Address: 100 Skylark Rd
(lot 15 of Skylark Commons Subdivision)

C-B-L: 349-I-003
permit # 2014-01056

CHECK-LIST AGAINST ZONING ORDINANCE

Proposed Use/Work - build new single family - footprint 28' x 31' (includes porch & deck)
get two stories (garage in front } full 2.5 story in back)

FRONT ELEVATION
Scale: 1/4" = 1'-0"

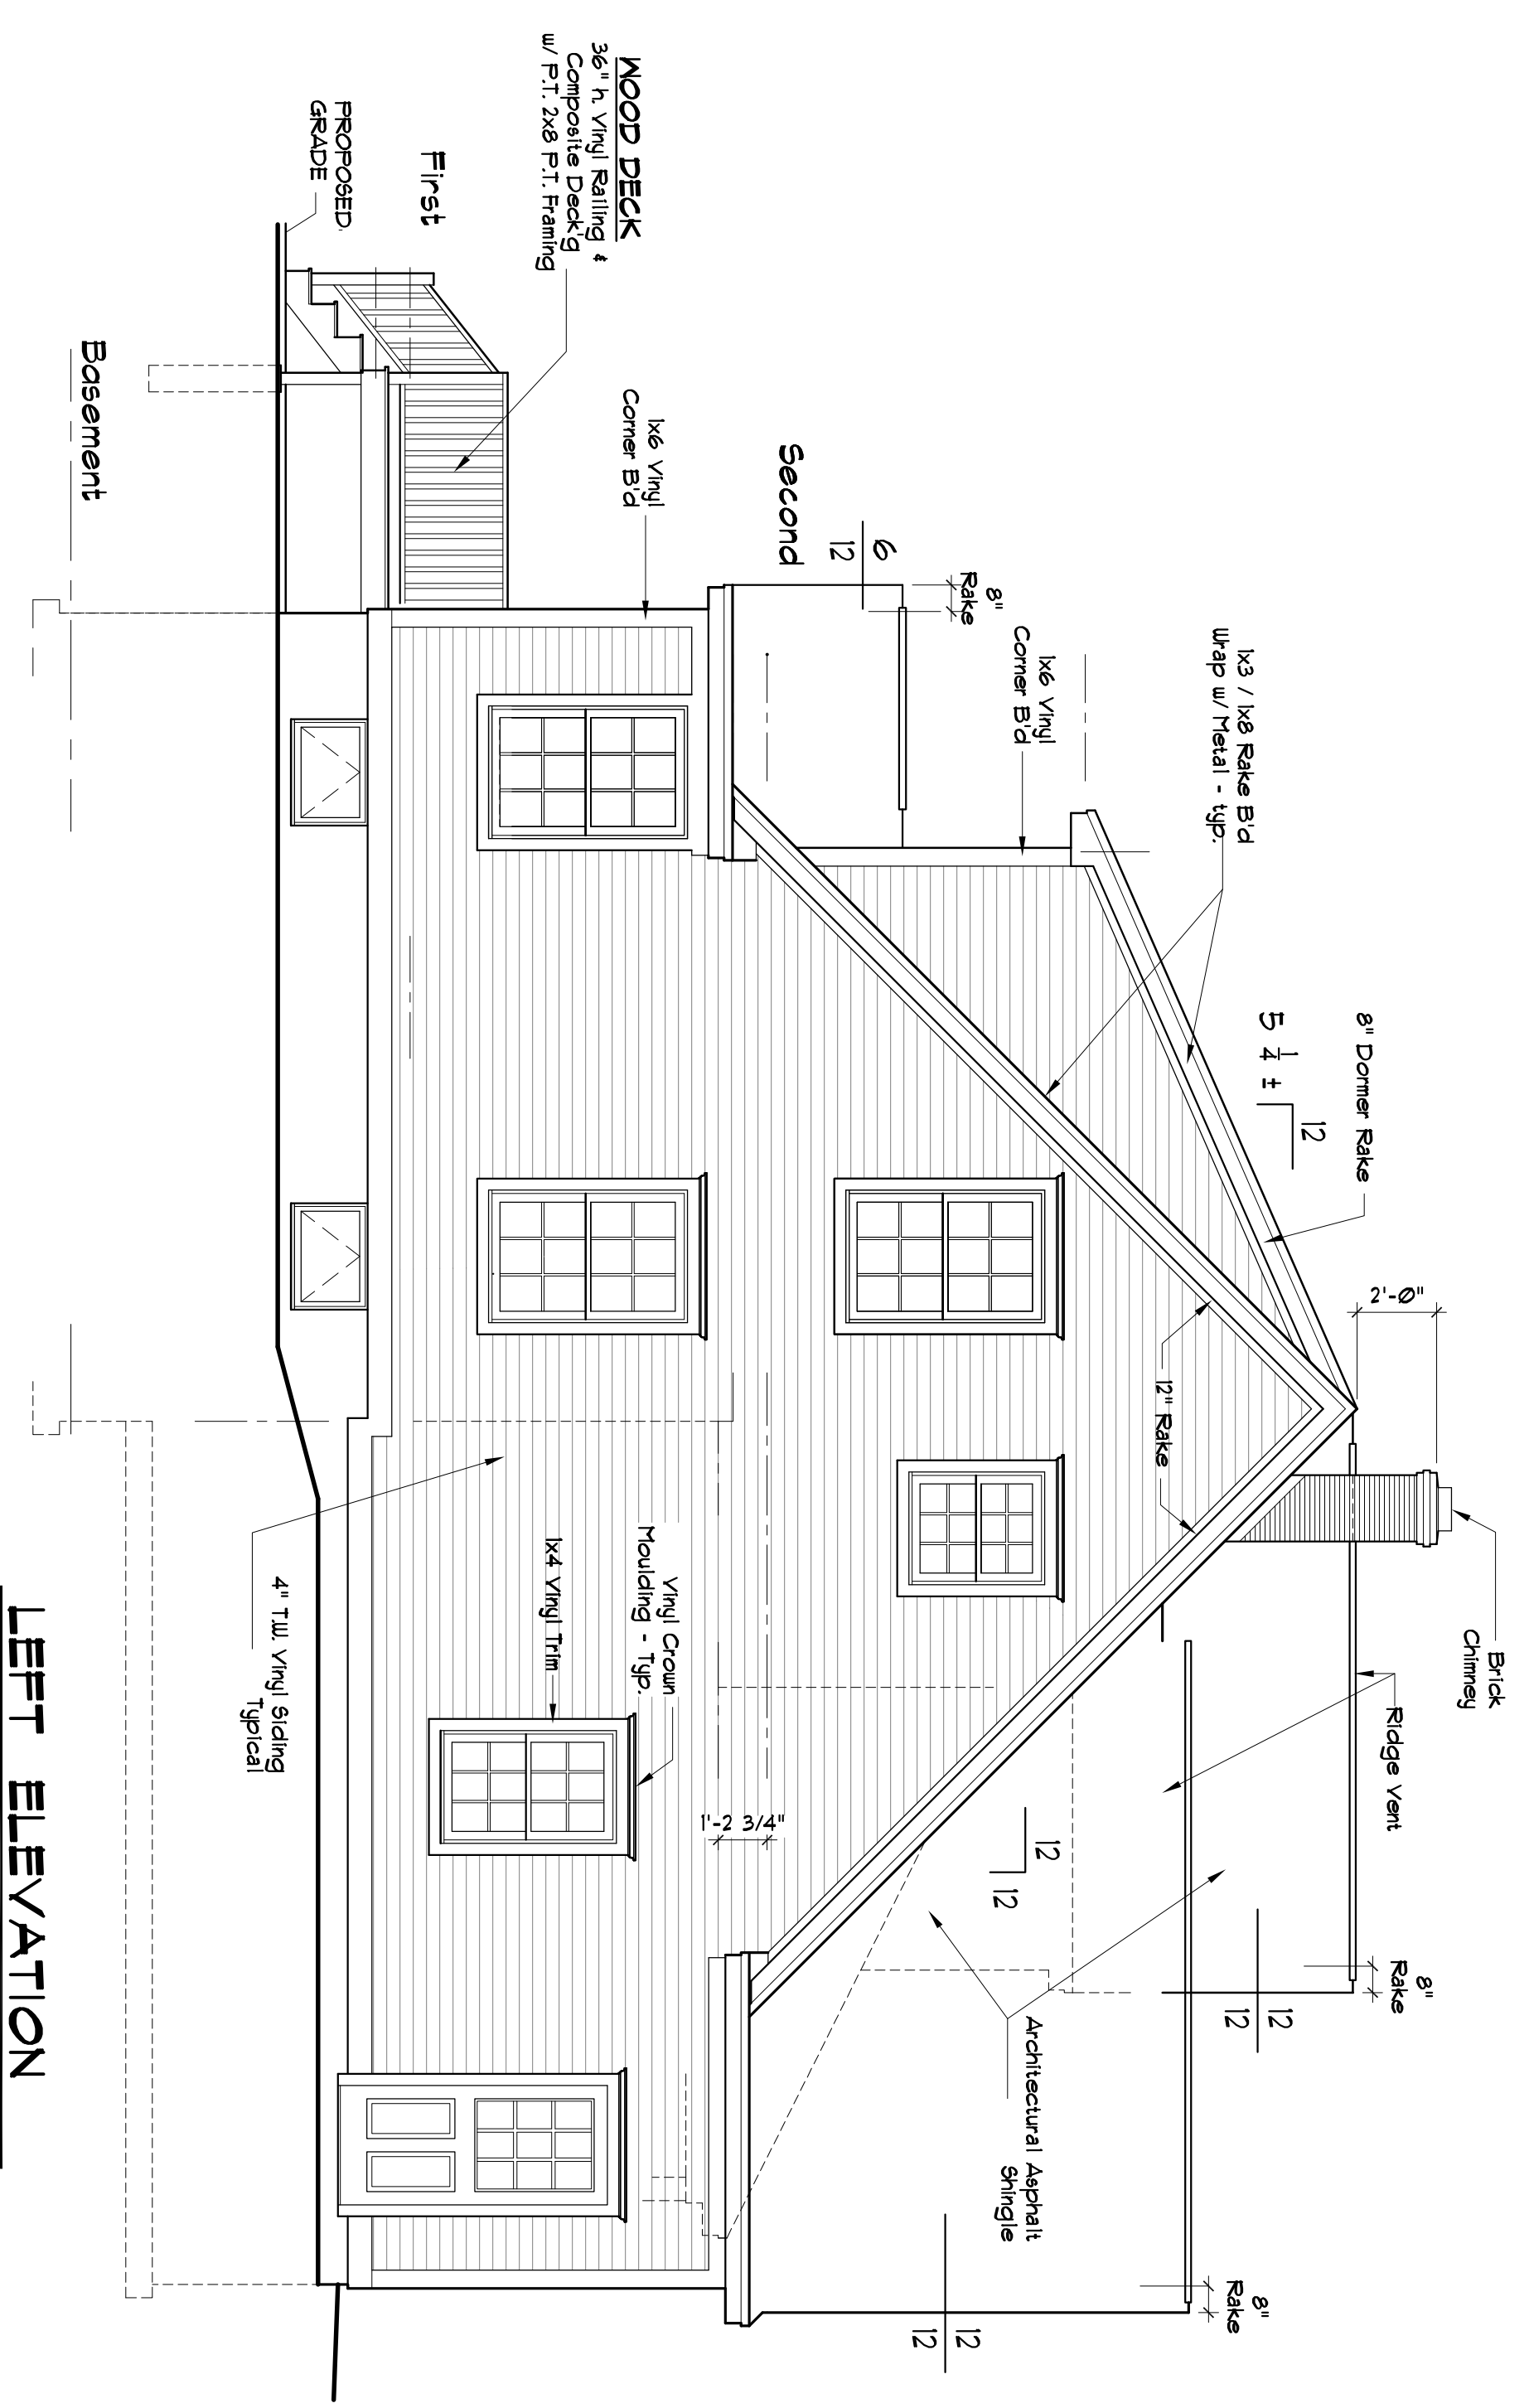
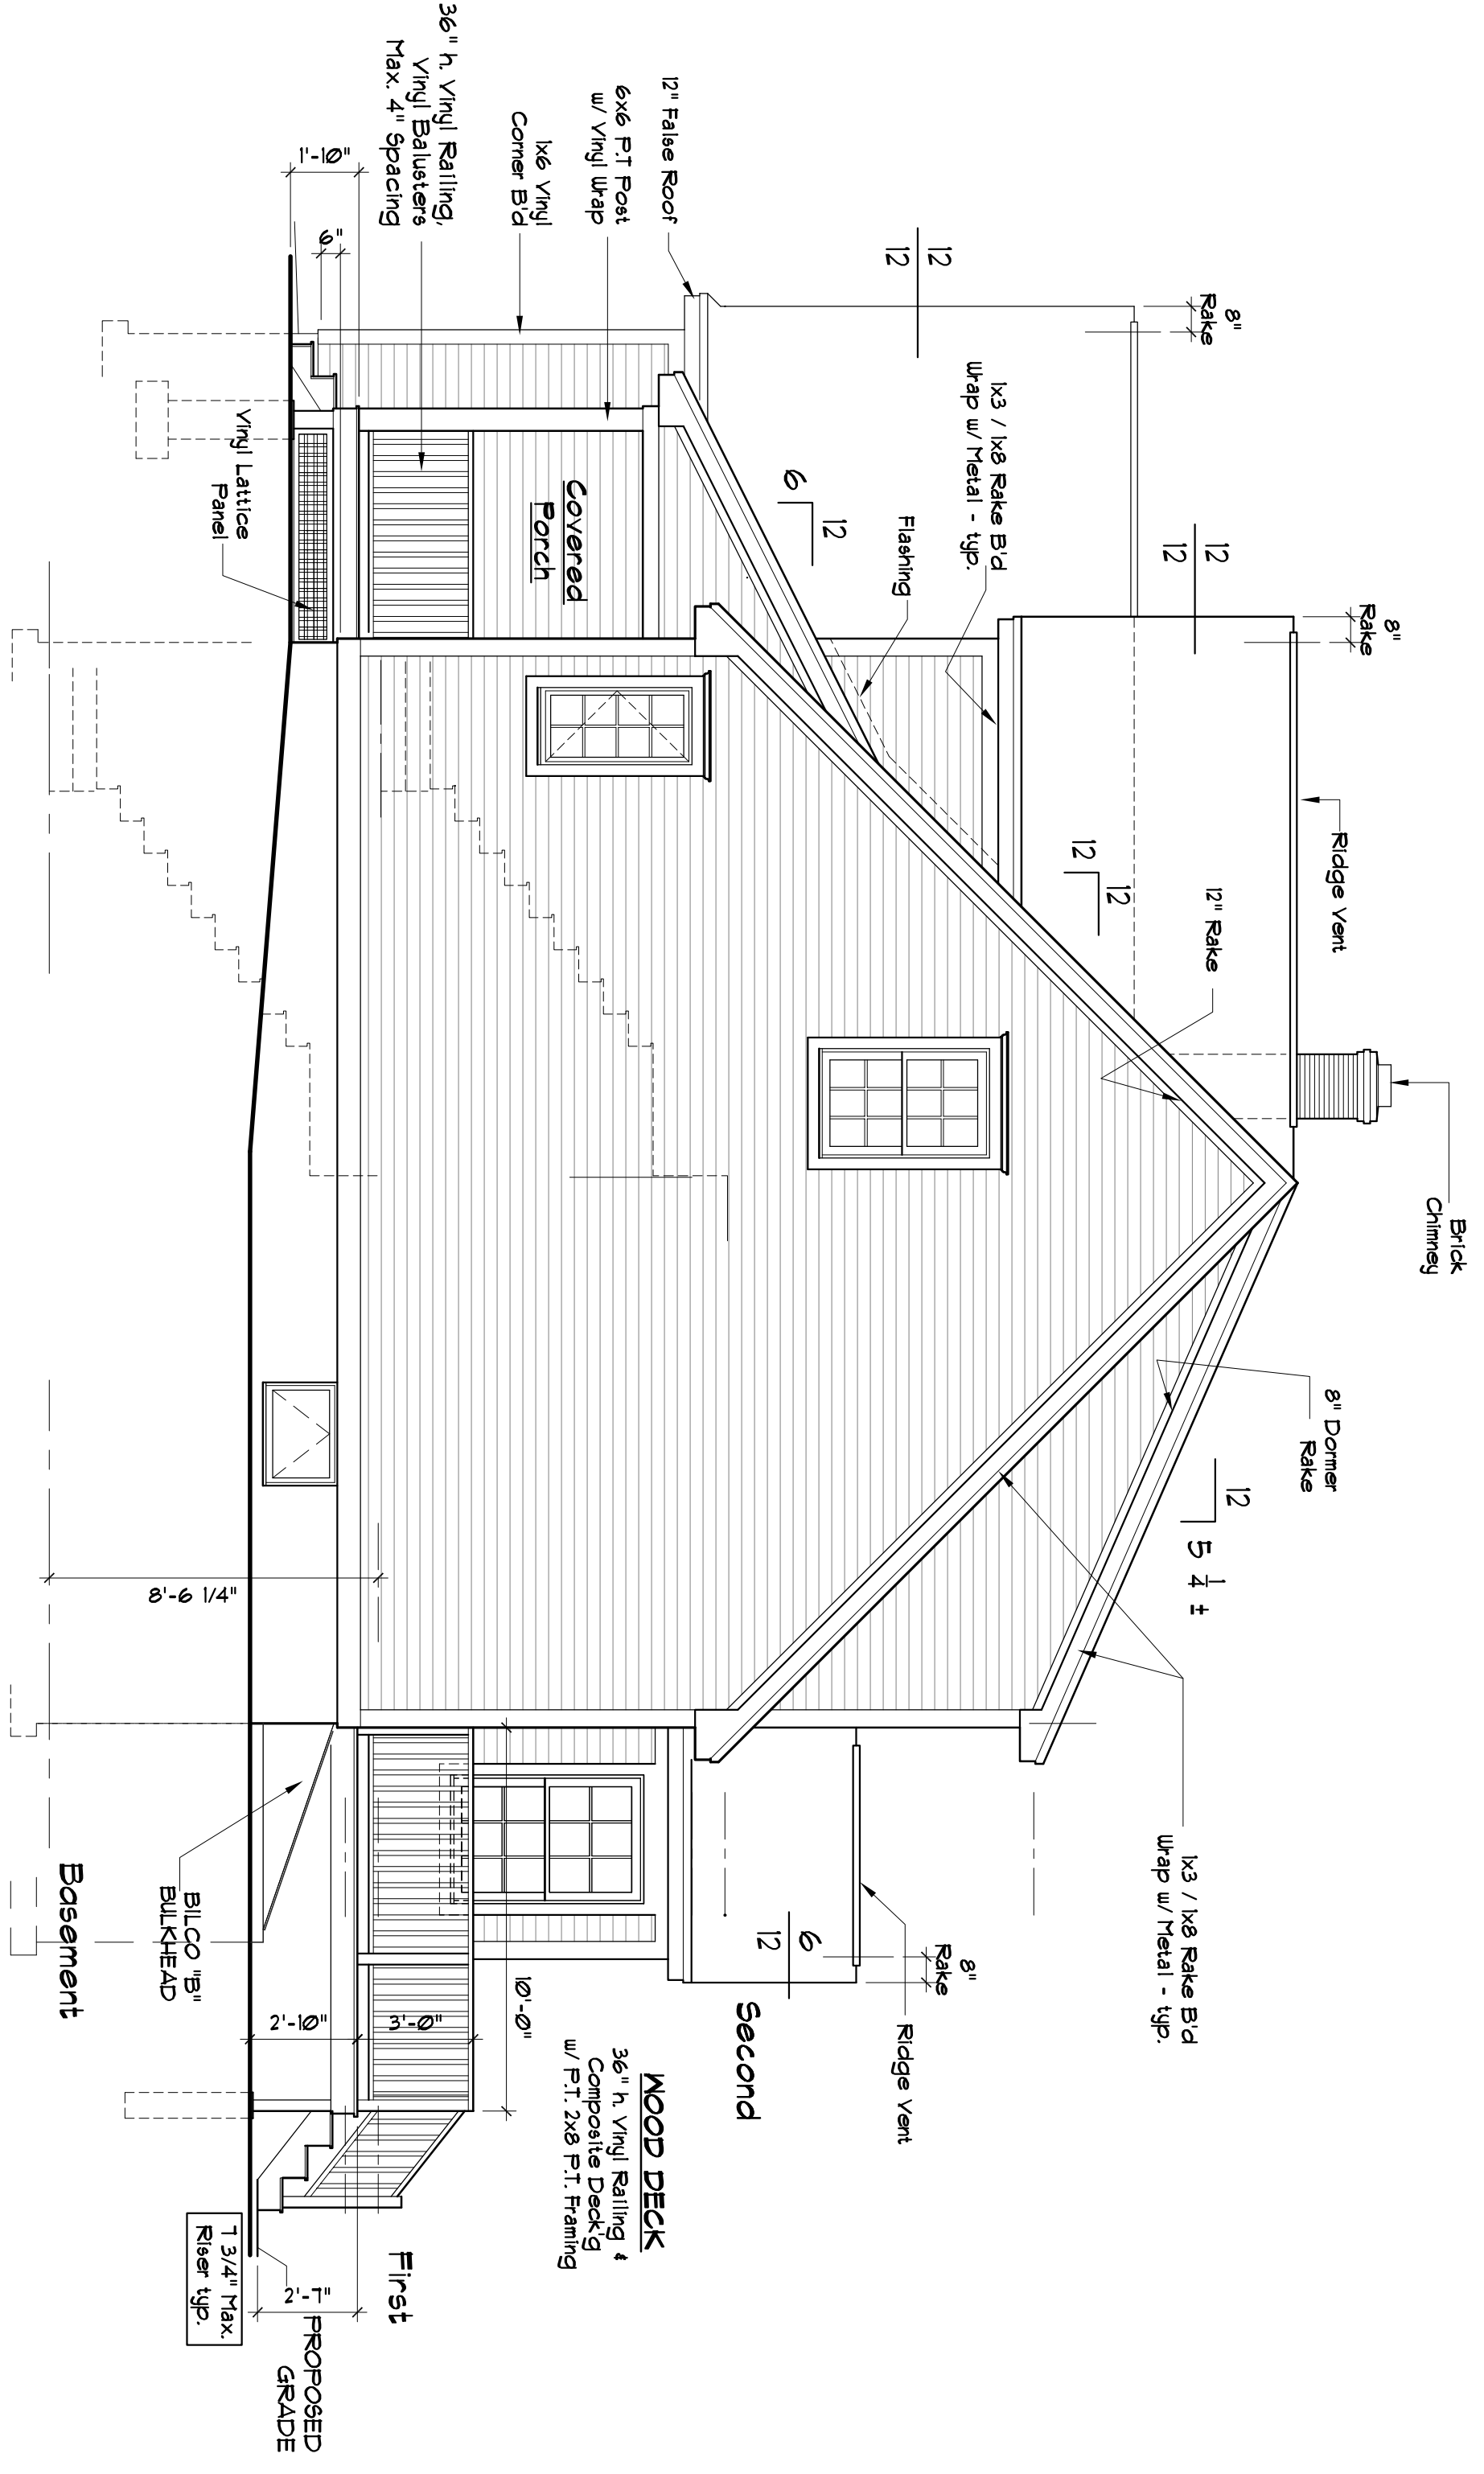
Height - 35' max - 27' from lowest grade bridge (OK)
